WEST SUSSEX COUNTY COUNCIL CONSULTATION

TO:	Arun District Council- FAO: Simon Davis
FROM:	WSCC - Highways Authority
DATE:	3 December 2020
LOCATION:	The Beach Hotel, former Mud Club, Waterloo Square, Bognor Regis, PO21 1SU
SUBJECT:	BR/244/20/PL Redevelopment into 11 No. 2 bed apartments & 2 No. commercial units (A1 Retail or A3 Restaurant/Cafe) (resubmission following BR/282/19/PL). This application affects the character & appearance of The Steyne, Bognor Regis Conservation Area & may affect the setting of listed buildings. This site is in CIL Zone 4 (Zero Rated) as flats & other development.
RECOMMENDATION:	No Objection

Project Title:	Date:
Waterloo Square, Bognor Regis	06.10.2020
Document Title:	Drawn by / Checked by:
Proposed Site Layout Plan	SR / GG
Drawing Scale / Sheet Size:	Client:
1:500 @ A3	B5 ltd
Drawing Status:	Drawing Number / Revision:
PLANNING	18.103.400

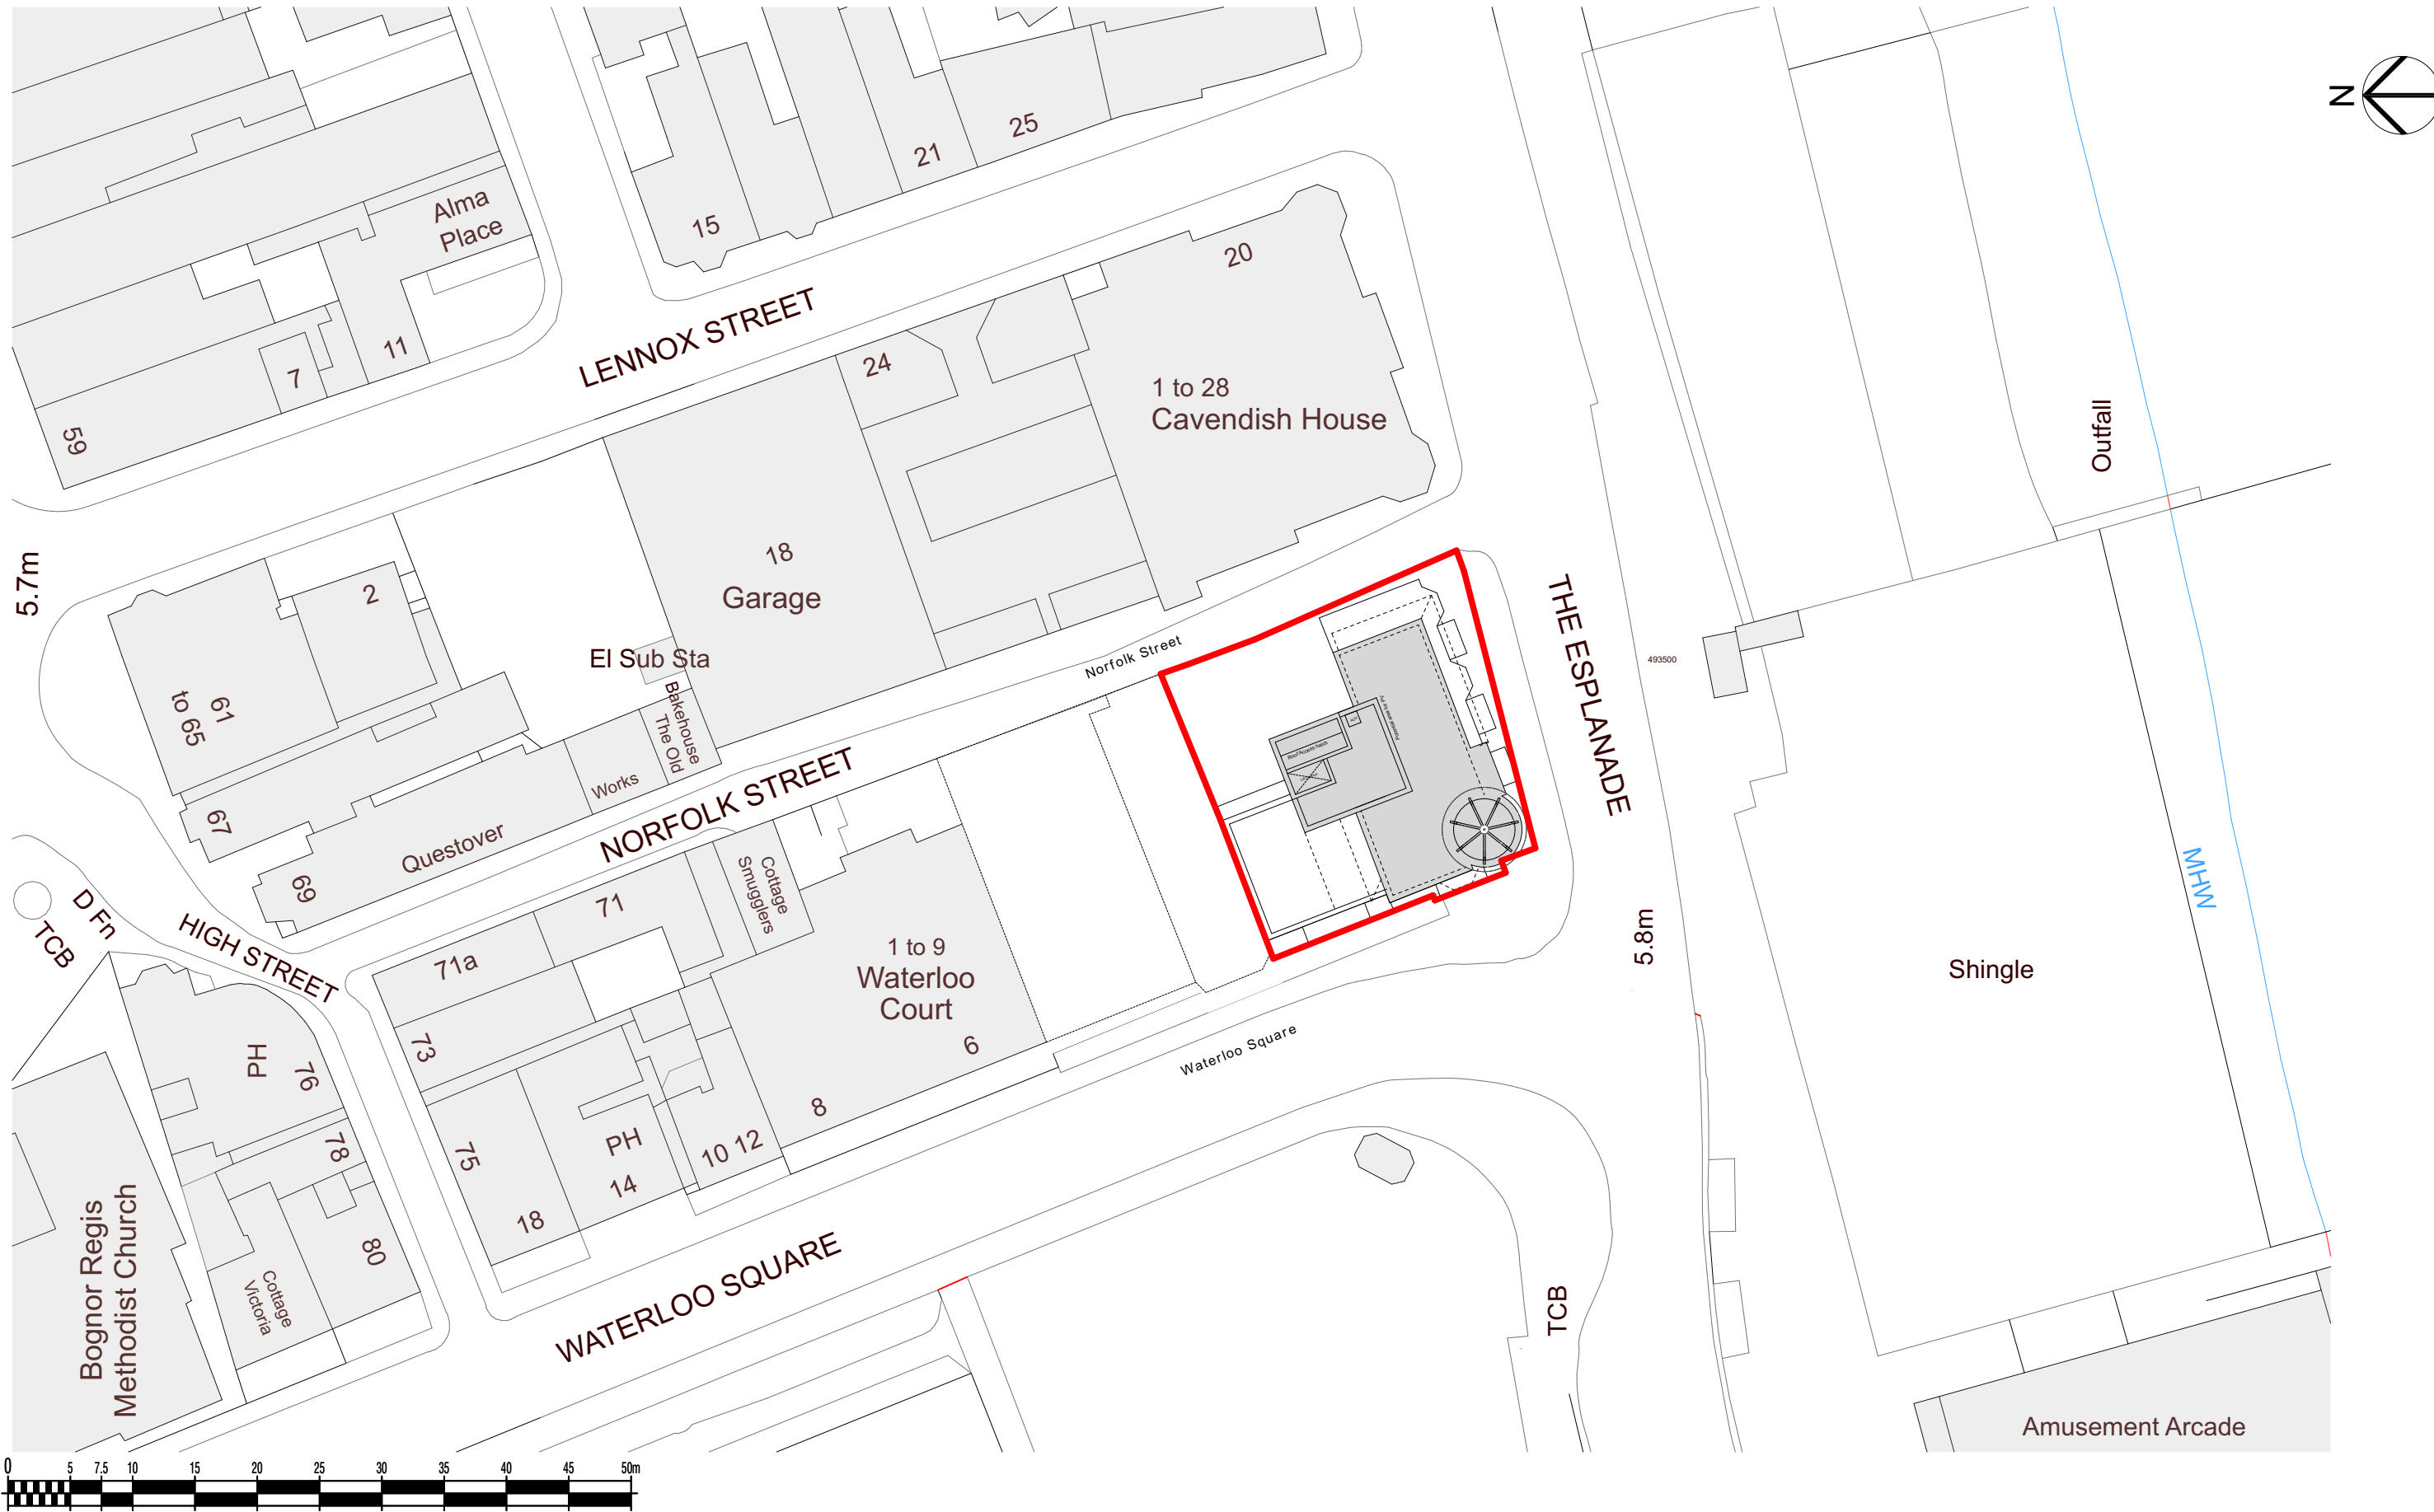
A new RSA has been carried out on the amended access arrangements. This has reviewed the proposals for vehicle access from Norfolk Street with 4 x car parking bays and cycling parking behind the bays. One issue was raised in relation to the boundary treatment for the northern boundary of site. It was advised that boundary treatment should be kept below 1.05m in height to allow drivers exiting the site visibility to Norfolk Street. The DR states that no boundary treatment will be provided in this location and the LHA consider that this suitably addresses the issue. The LHA, as Overseeing Organisation, has completed the DR which is sent to the LPA under separate cover.

Swept path tracking plans have been provided to demonstrate that a car can access each proposed parking space. Considering the restricted width of Norfolk Street some of these manoeuvres appear restrictive and may result in a slight vehicle overhang to the opposing footway. Nevertheless, the LHA consider that a multi-point manoeuvre could be carried out if required and no highway safety concern is raised to the proposed arrangements. One of the bays has been marked for disabled use and one has been marked for potential electric vehicle charging point.

Swept path tracking plans have also been provided for a servicing vehicle which shows anticipated vehicles will be able to manoeuvre to and from the loading bay area and that a vehicle can pass on Norfolk Street.

No part of the development shall be first occupied until such time as the vehicular access serving the development has been constructed in accordance with the details shown on the approved plans.

No part of the development shall be first occupied until the car parking has been constructed in accordance with the approved site plan. These spaces shall thereafter be retained at all times for their designated purpose.
